MEMORANDUM

TO: Molly Casto
FROM: Dan Goyette, PE, and Lauren Swett, EIT
DATE: December 19, 2007
RE: Estates of Longfellow Inn

Woodard & Curran has reviewed the site plan submission for The Estates of Longfellow Inn. The project proposes to renovate and add to an existing multifamily residential building located at 130 Eastern Promenade in Portland. The garage for the existing building will be demolished and replaced with paved parking, and an expansion will be added to the building to provide room for seven units.

This memo provides one comment as an addition to the memo sent on December 4, 2007.

2 CONCRETE SIDEWALK
 NOT TO SCALE

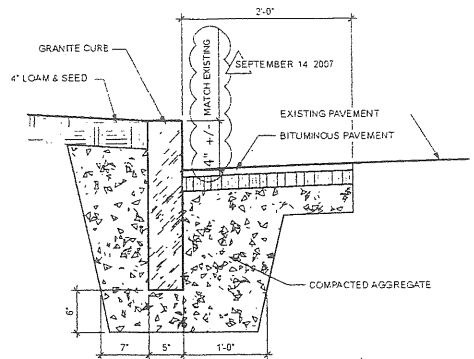
- The applicant may repair the sidewalk with concrete if the disturbed length is less than 10 feet, and kept within 2 sections of concrete sidewalk. If a larger disturbed area of sidewalk is required, the sections must be replaced with brick sidewalk. If the sidewalk is not part of an historic area, the option exists for concrete paver bricks to be used as an alternative to clay bricks.
